## 1039 Riverside Street - Final Traffic Comments

Jean – I have reviewed the most recent plans and I find them acceptable with the following comment:

FLOOR PLAN

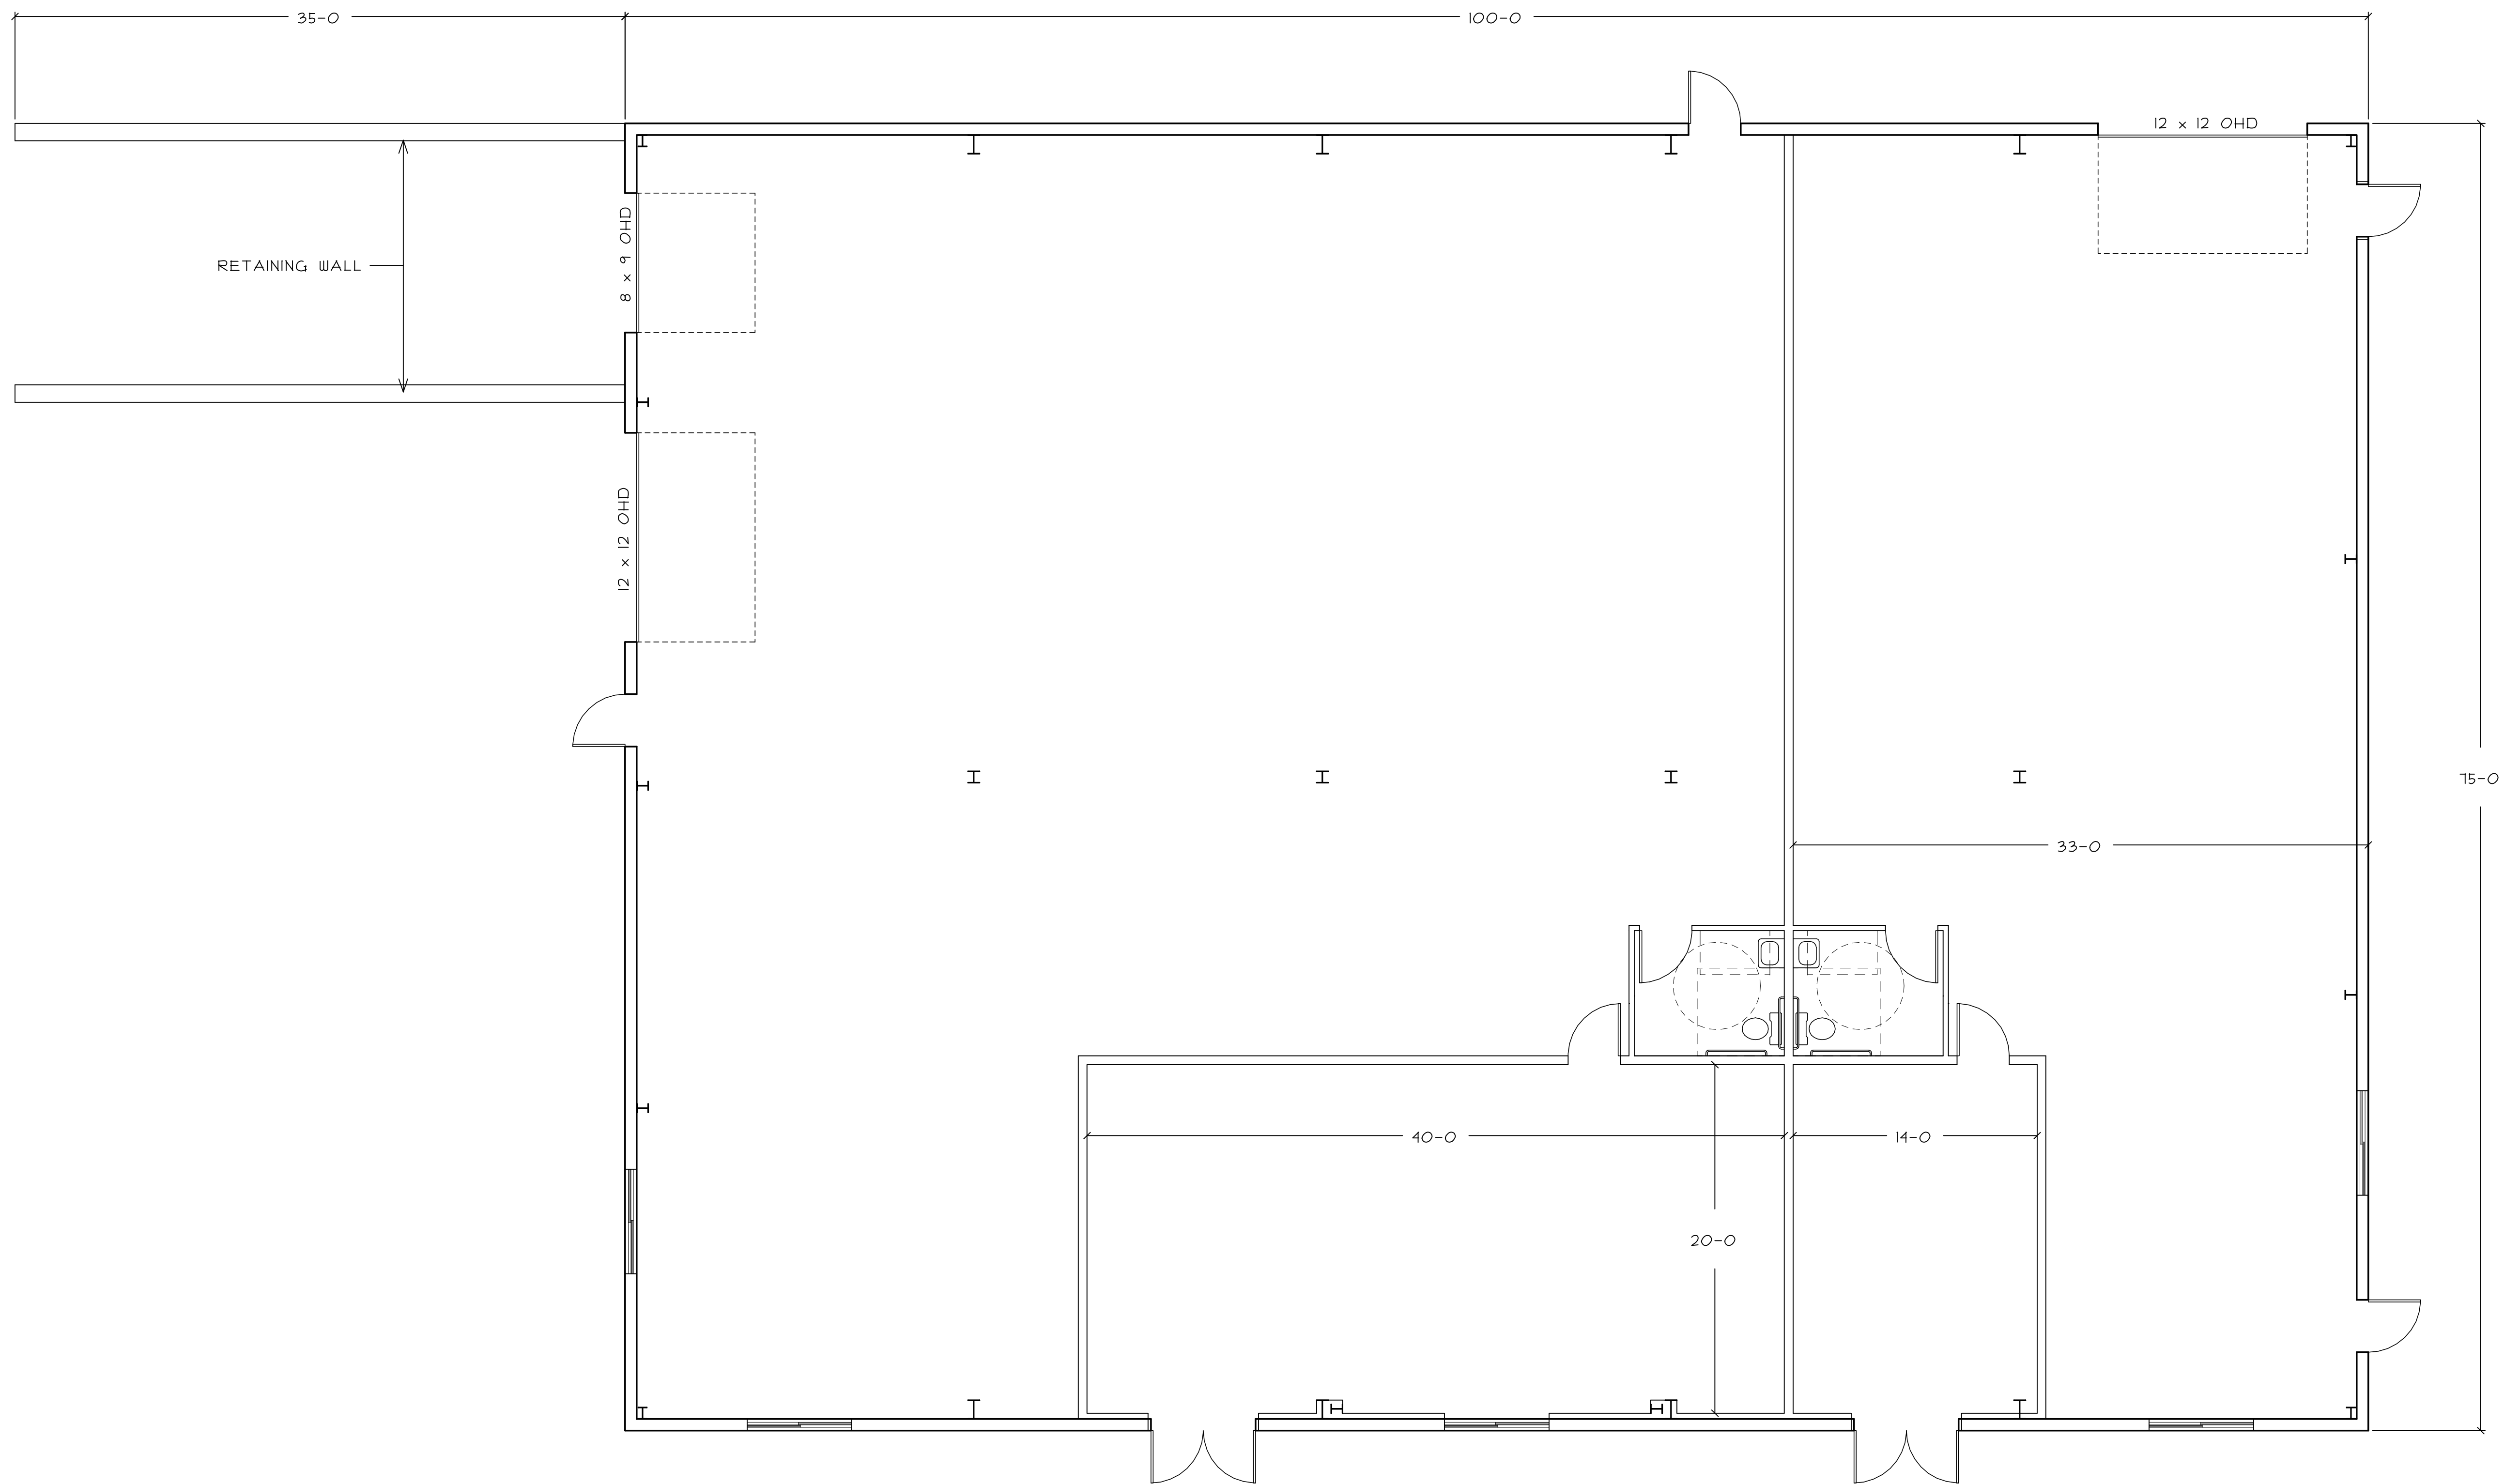
- If the at-grade overhead door on the internal roadway is to be used frequently the parking spaces shall be removed and similar pavement markings to that used at the loading dock entrance shall be installed.
